CITY OF ALBUQUERQUE

Planning Department
Brennon Williams, Director

**Re: Facility for Apple Canyon Gourmet
1301 Cuesta Abajo Ct NE
Traffic Circulation Layout
Architect's Stamp 09-19-2021 (D16-D002H)**

SHEET NO.
ARCH 002

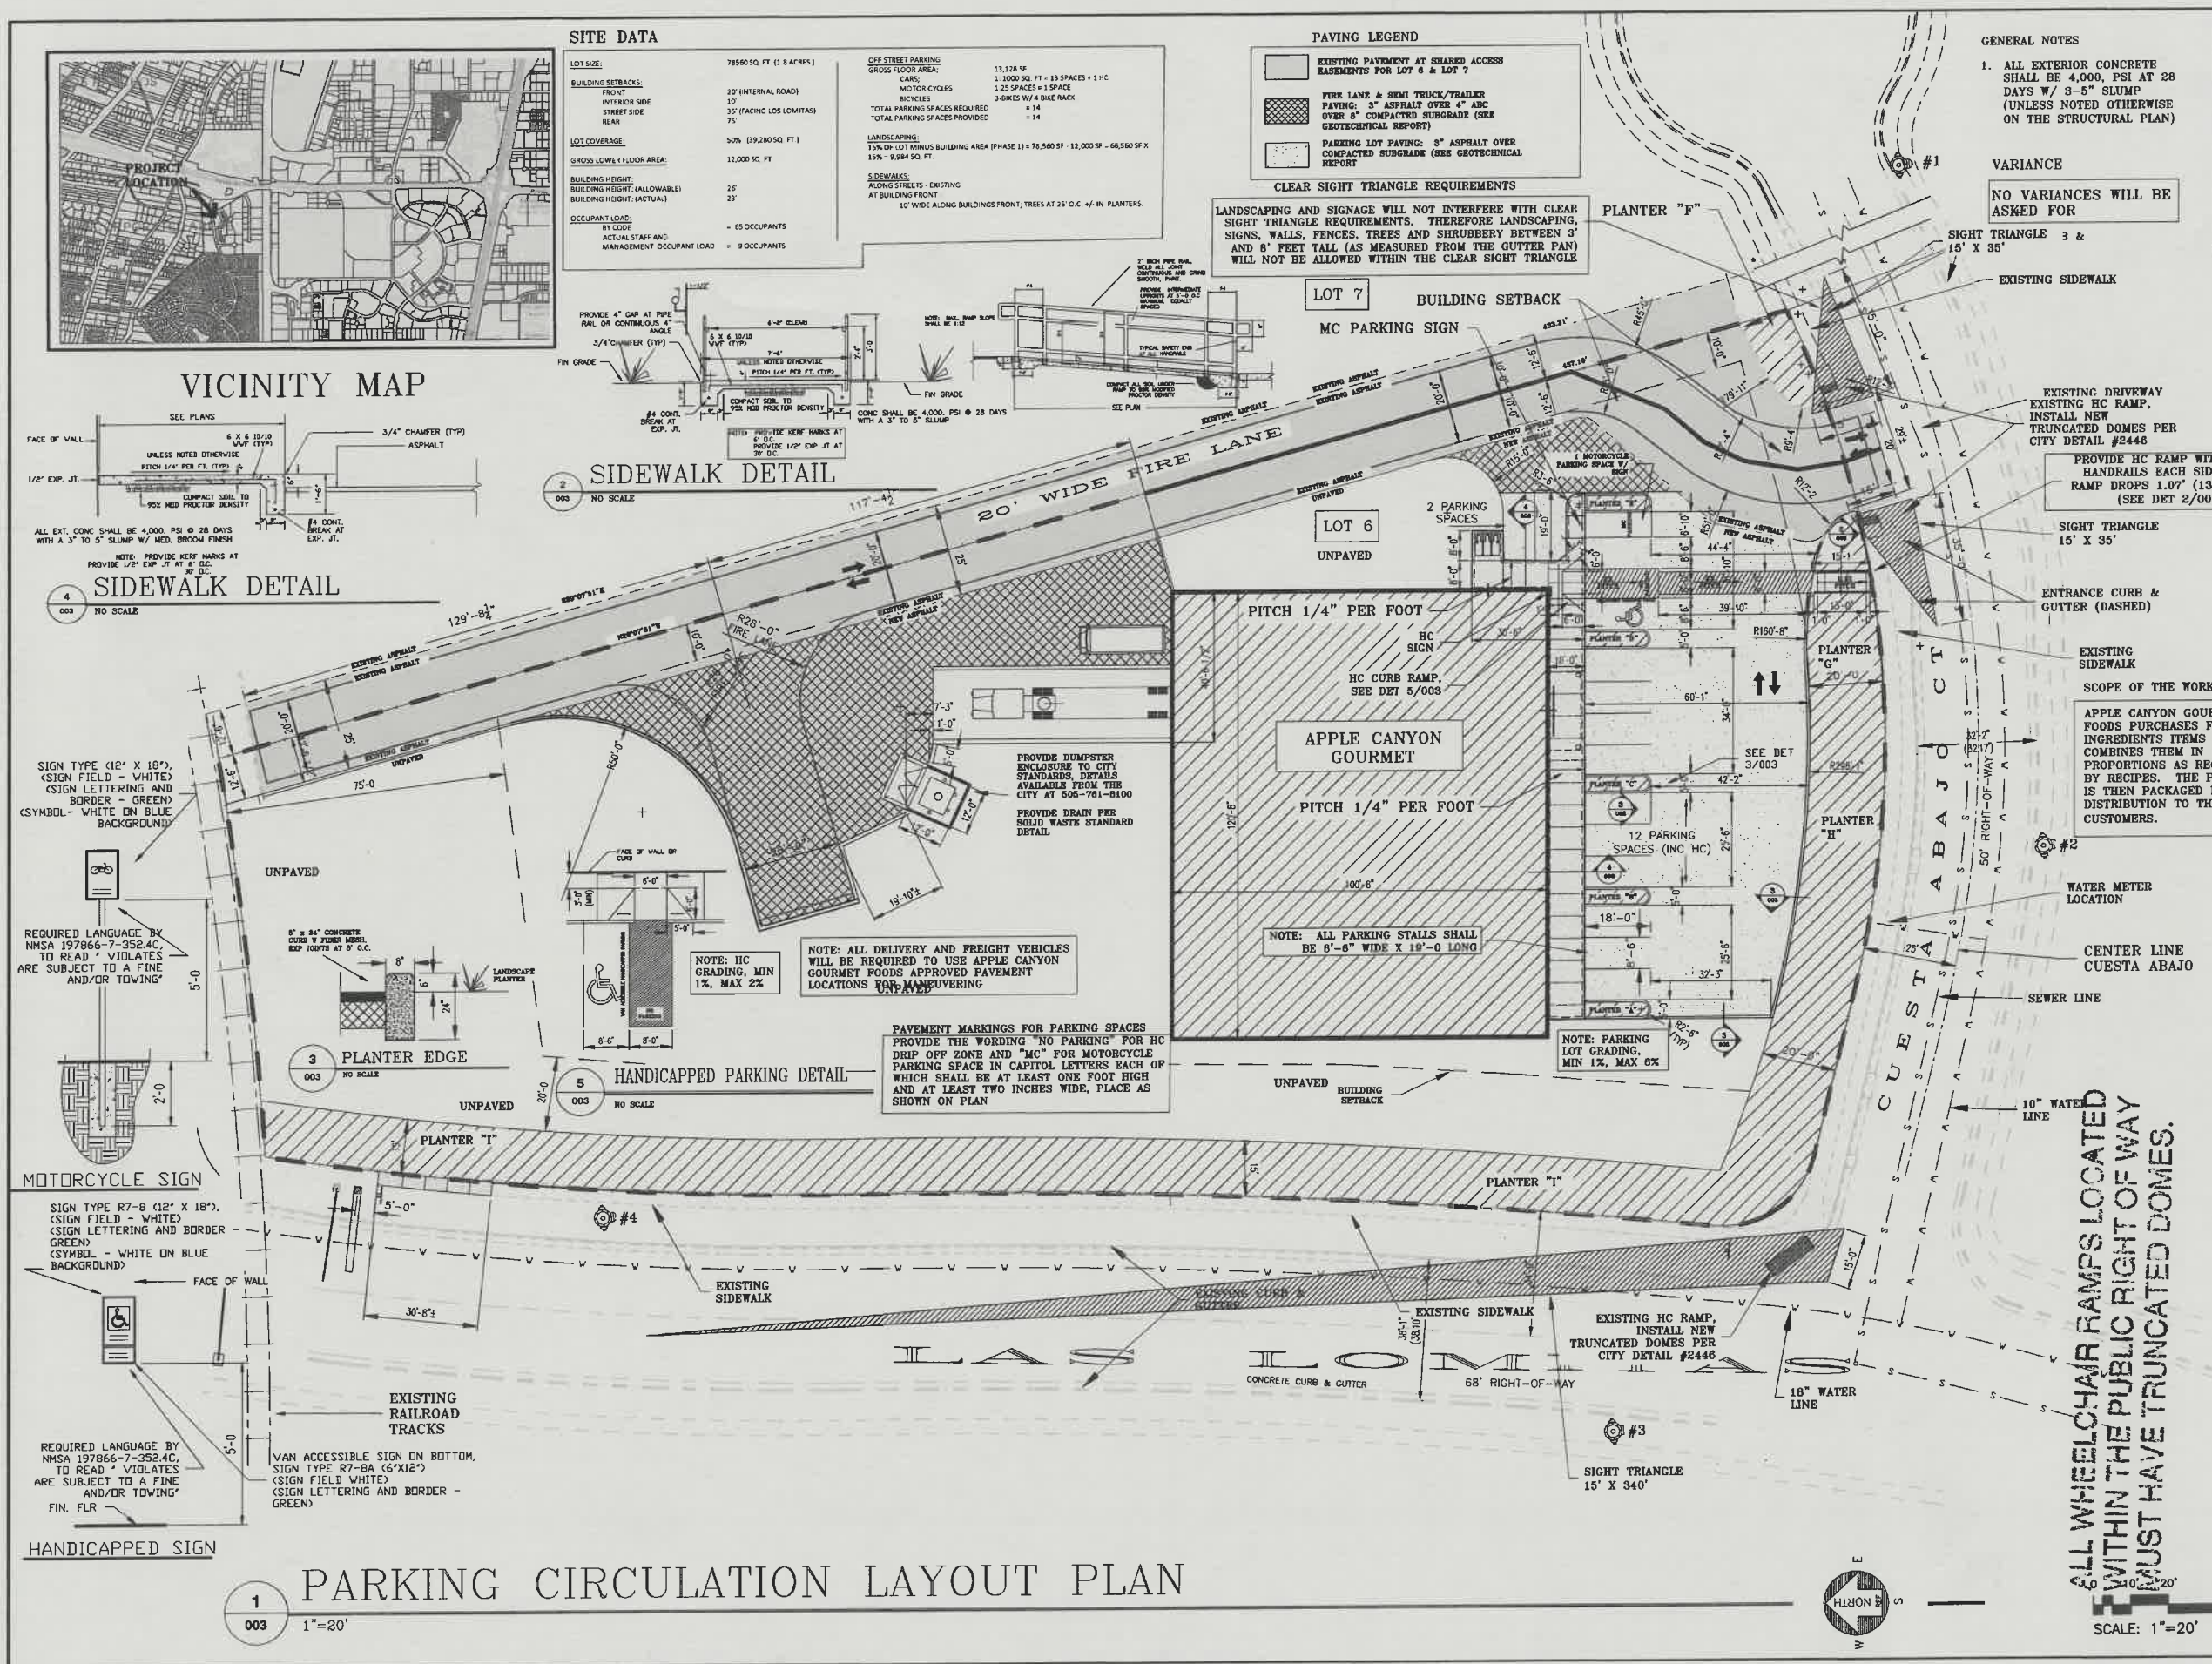
1. Sidewalk Extension on Las Lomas:

- The proposed sidewalk extension end limits will need to change since it conflicts with the RR Crossing Signal Infrastructure.
- Advanced signing specifying '**Sidewalk Closed A Head**' shall be placed north of the corner (Las Lomas/Cuesta Abajo) ADA ramp.

SHEET NO.
ARCH 003.3

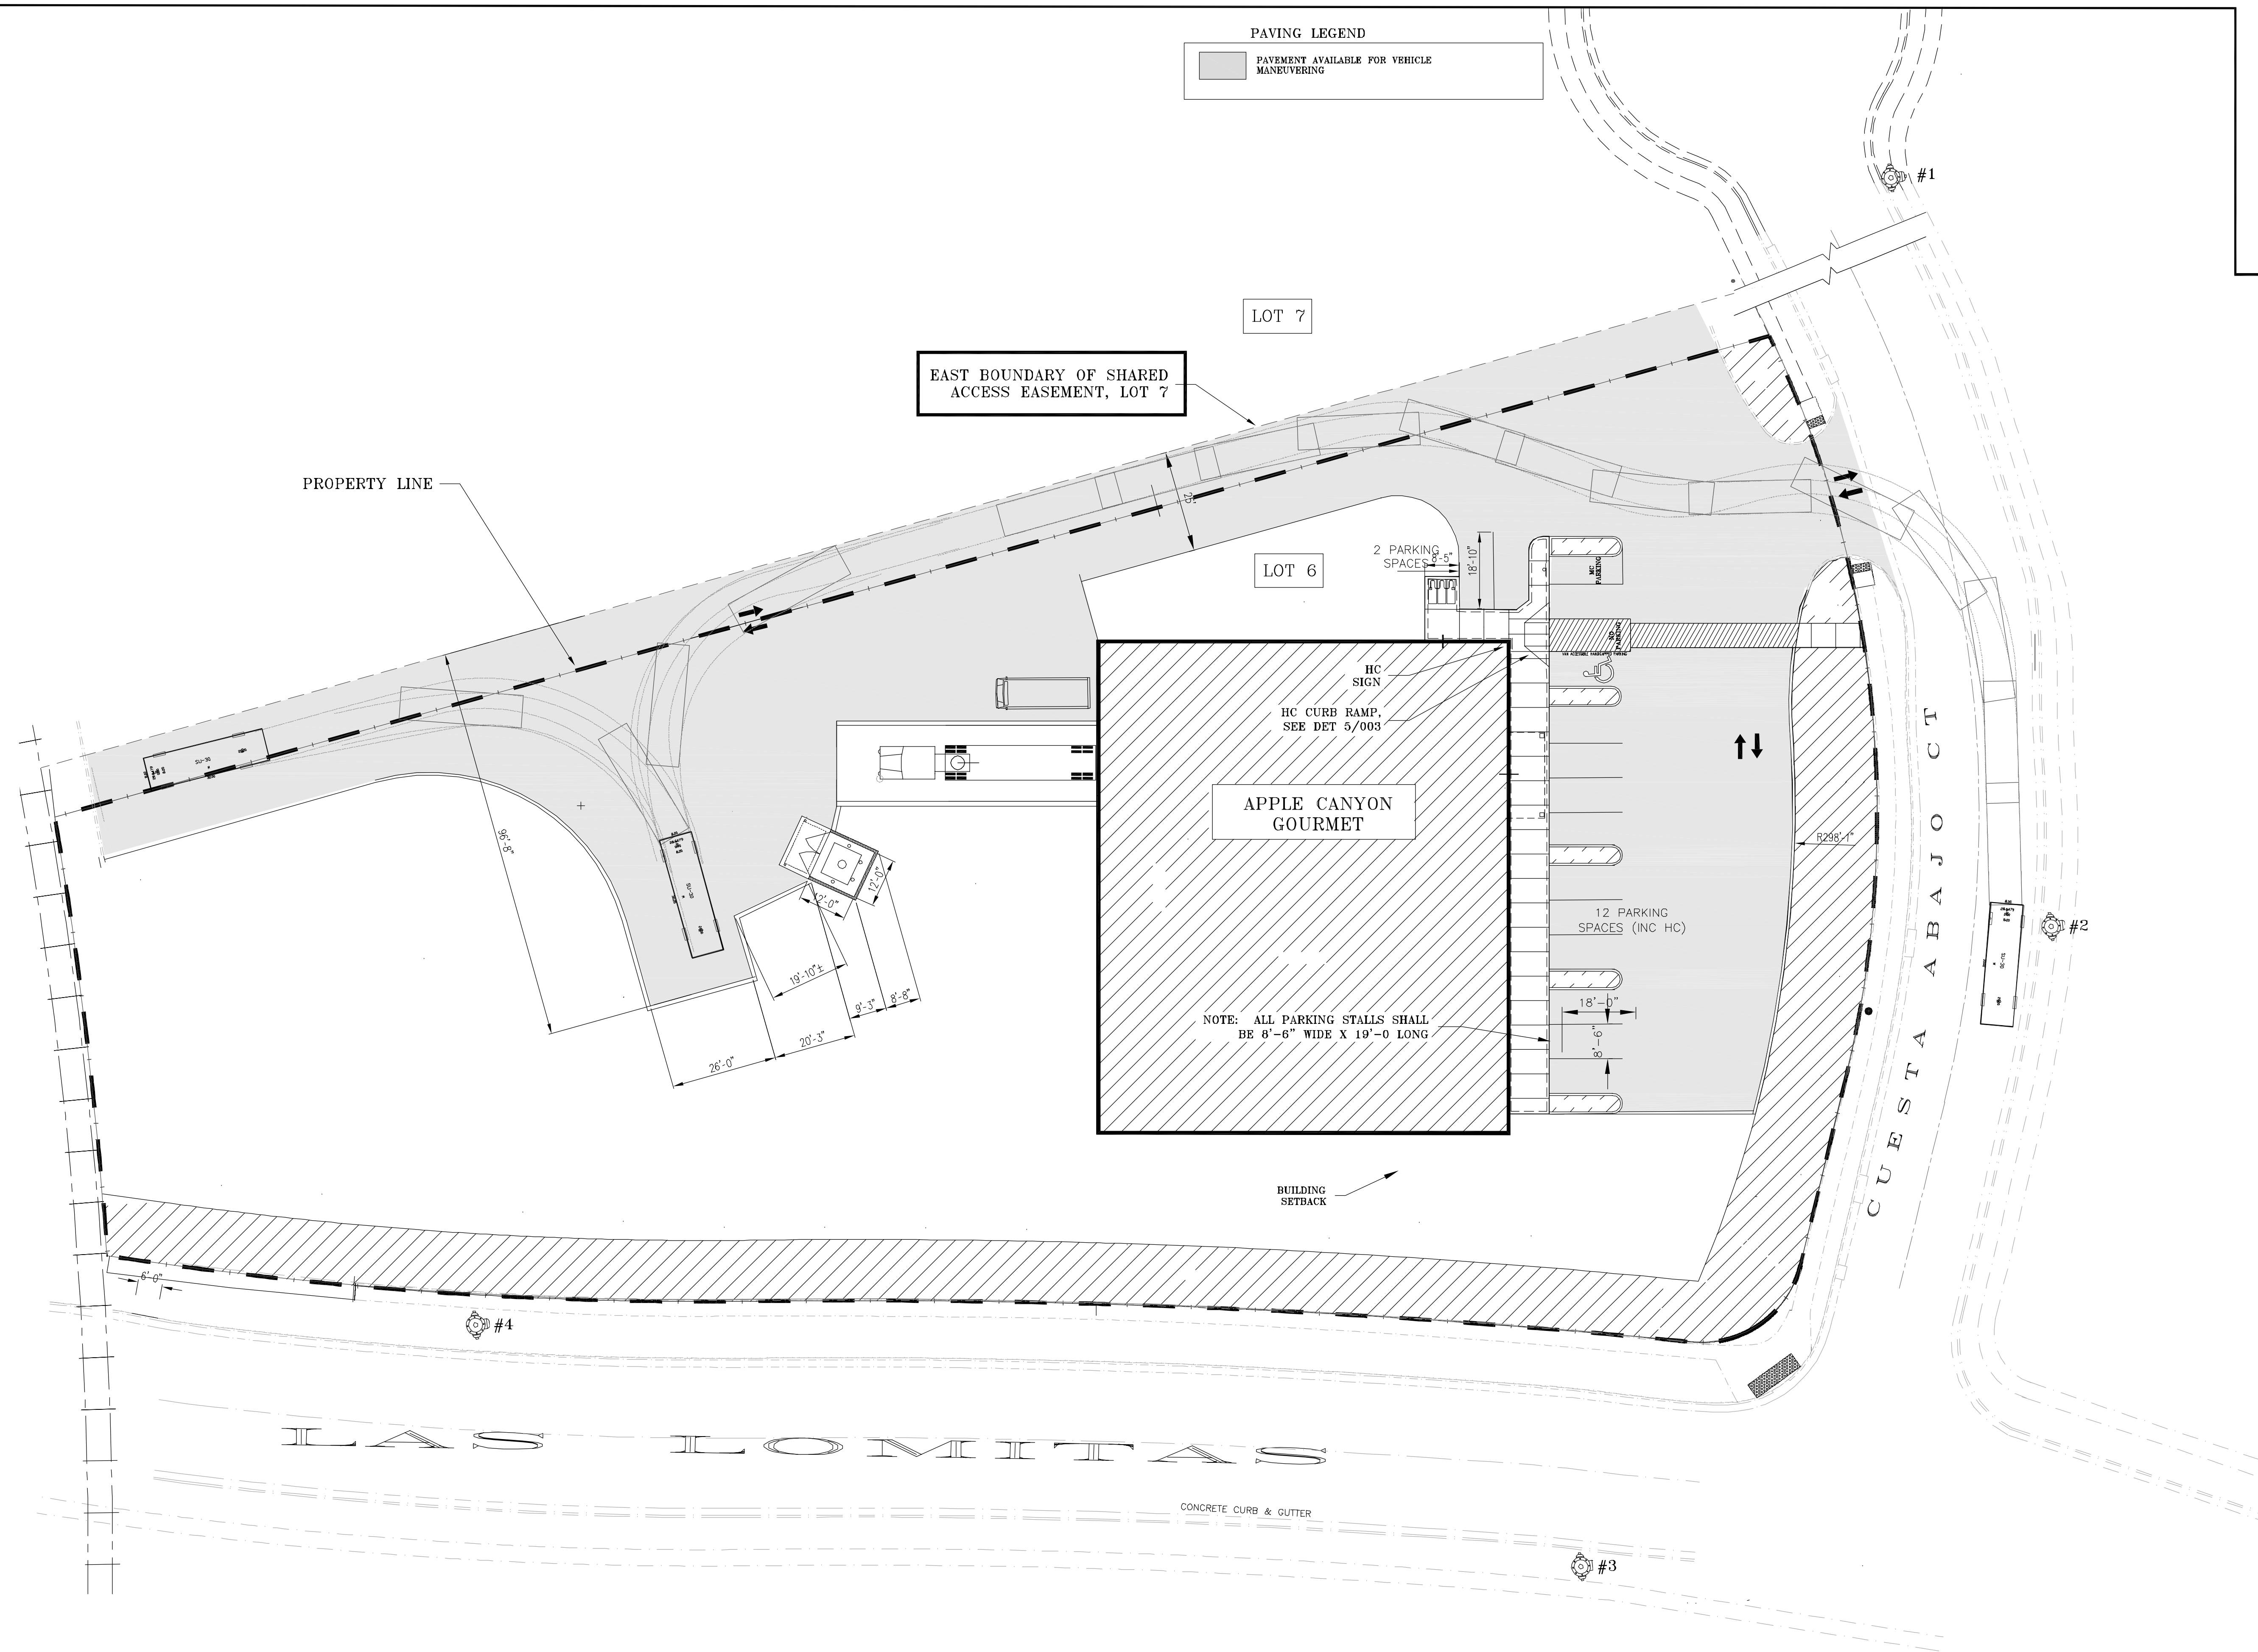
2. Exhibit Missing for Tract 7:

- **Provide another easement for Tract 7 since the delivery trucks and drive aisle are encroaching into this Tract.**
